Our reference: 7812382
Contact: Jane Hetherington
Telephone: (02) 4732 8078

Submission for Stage Significant Development Application Costco Wholesale Warehouse and Distribution Centre (SSD 8209)

I refer to your email regarding the Exhibition of Stage Significant Development Application Costco Wholesale Warehouse and Distribution Centre (SSD 8209) dated 29 August 2017. The plans and supporting information has been reviewed and the following comments are made for consideration with the assessment.

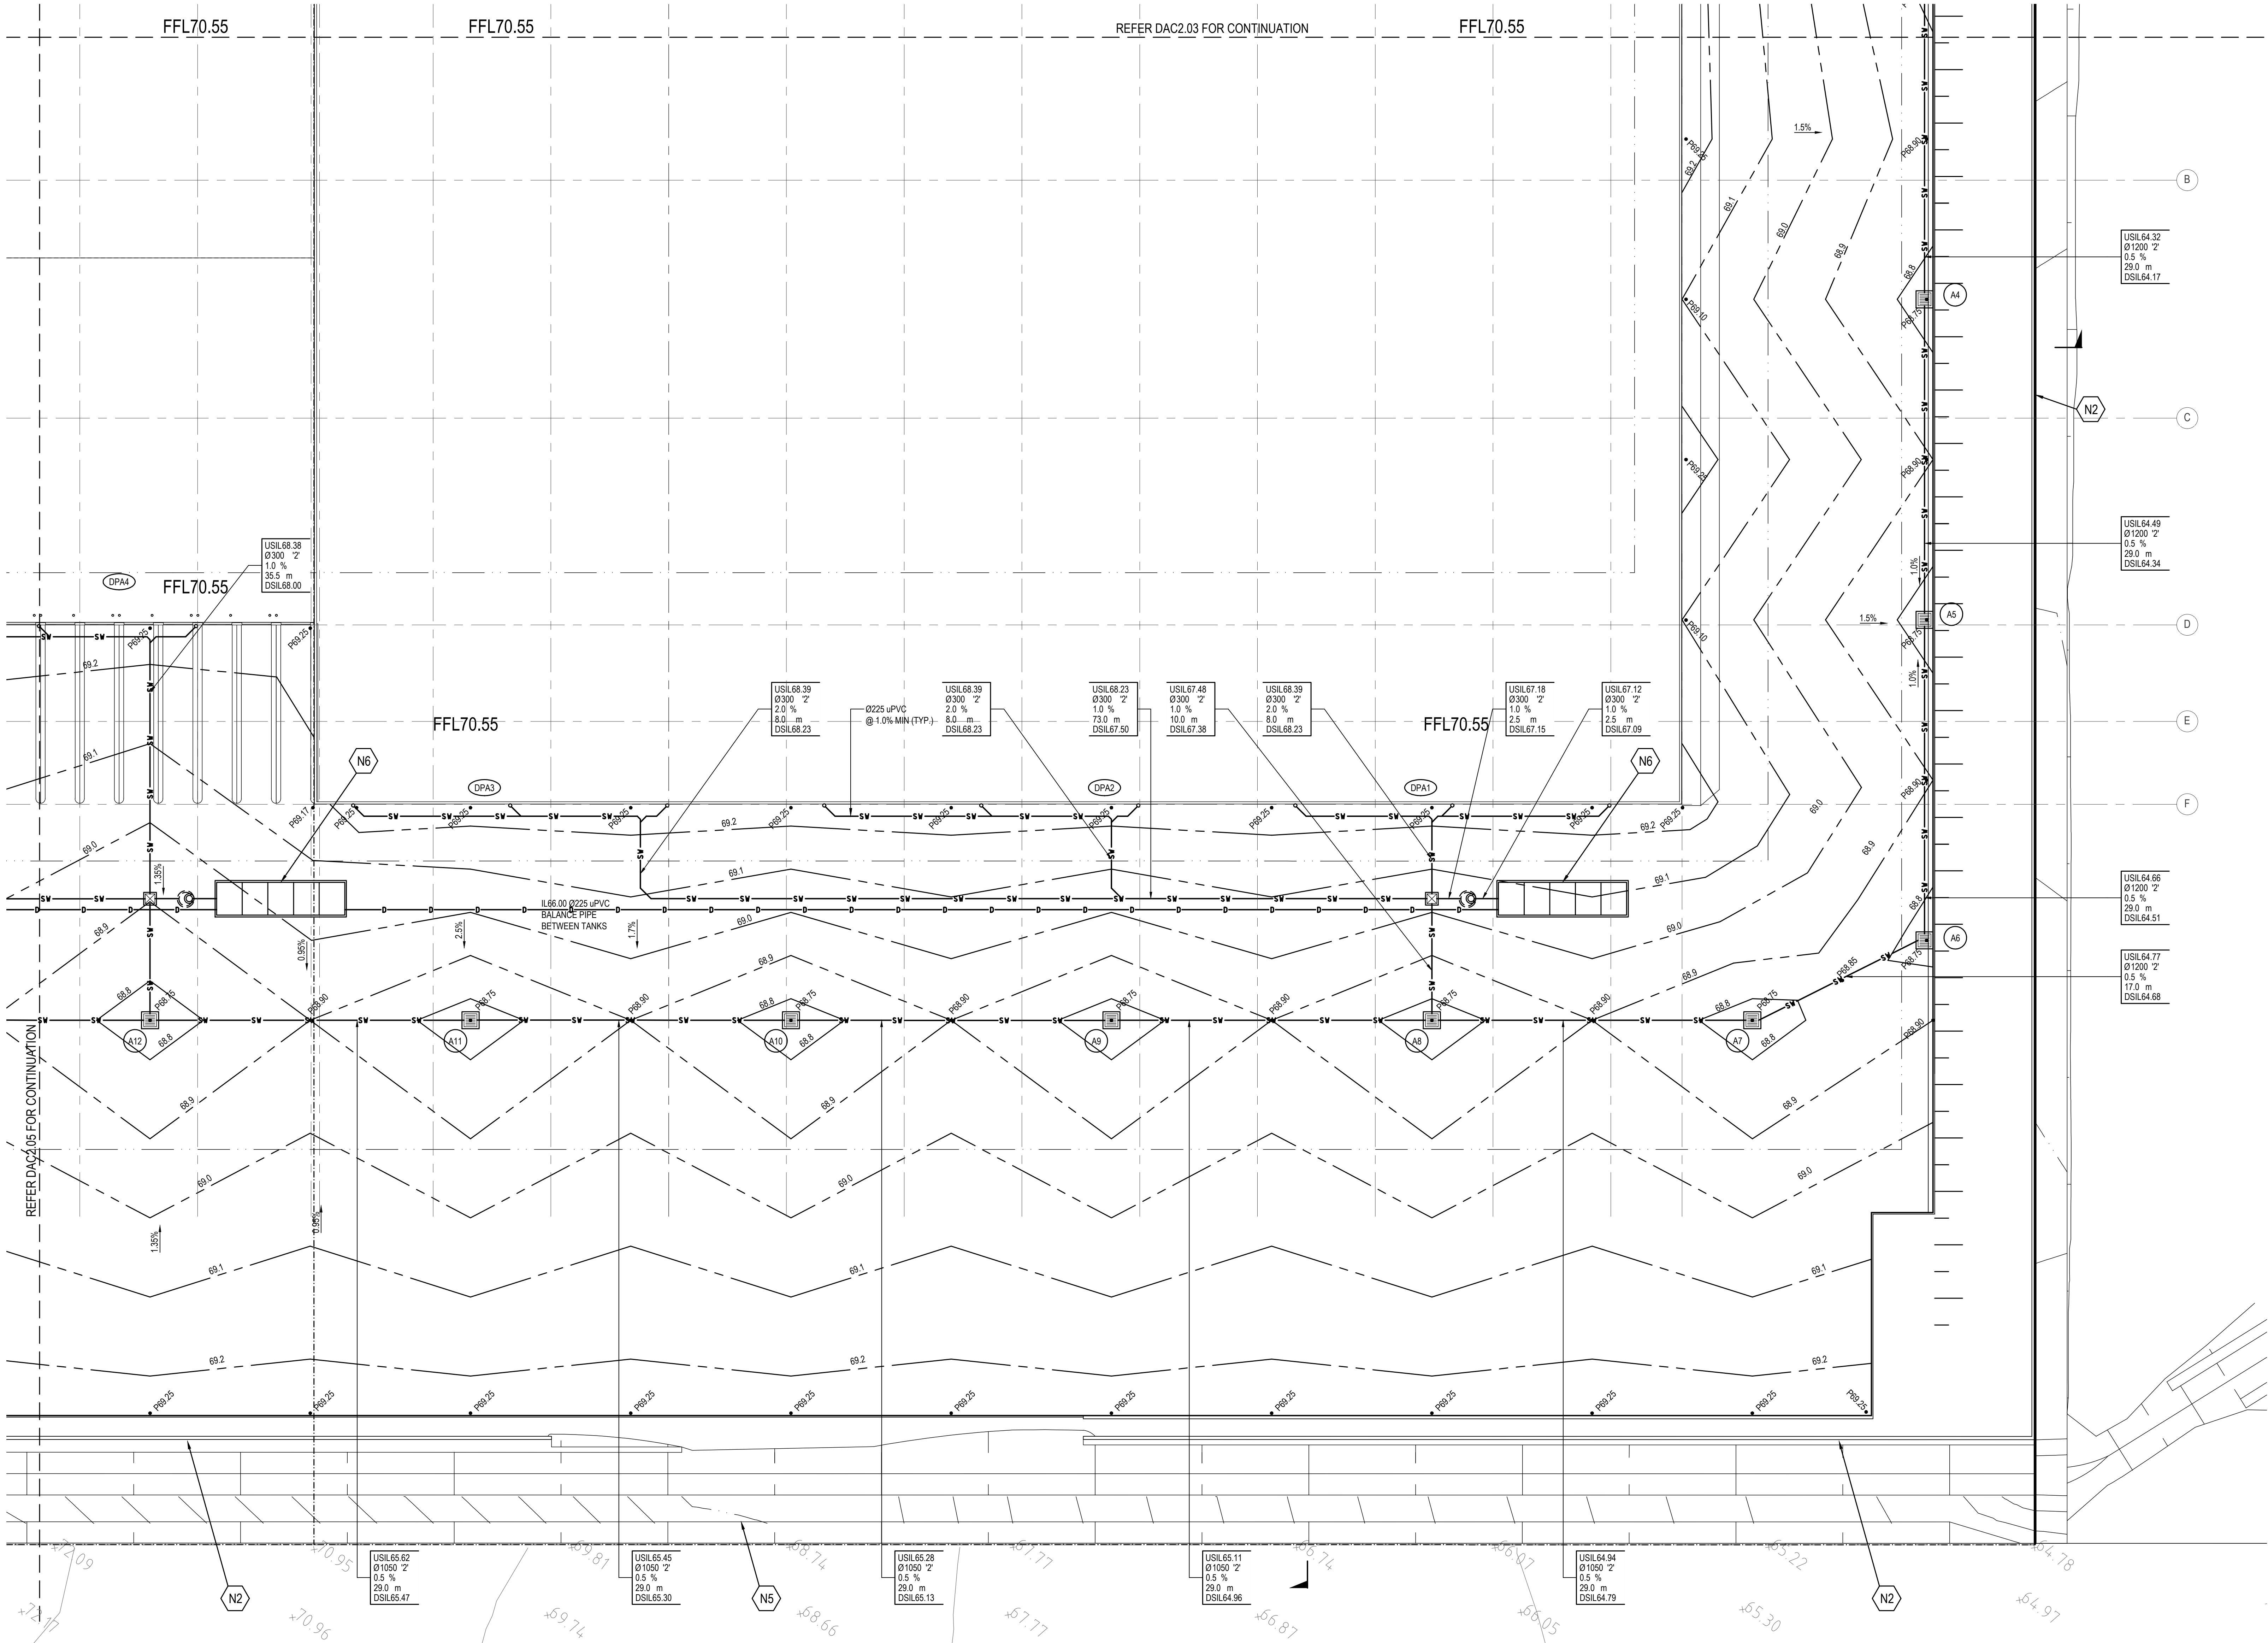
- The size and type of GPTs proposed has not been included on the Civil Works Plans or other documentation. The MUSIC modeling relied on for the entire OSE specified the on-lot GPTs as Rocla CDS type-units. Prior to Construction Certificate the proponent is to confirm the size and type of GPTs. If a substitute for the CDS-type GPTs is proposed the MUSIC modeling must be redone and resubmitted to ensure the overall water quality targets are not compromised.

- There is a discrepancy between the Water Management Plan and the Sustainability Management Plan regarding the sizing of the rainwater tanks proposed. The Sustainability Management Plan drastically underestimates the size of rainwater tanks required (i.e. only 50KL for the entire 14.27 ha site). The 450KL rainwater tanks for Stage 1 as proposed by the Water Management Plan is consistent with the requirements of the DCP 2014 for water reuse and conservation in an industrial development.
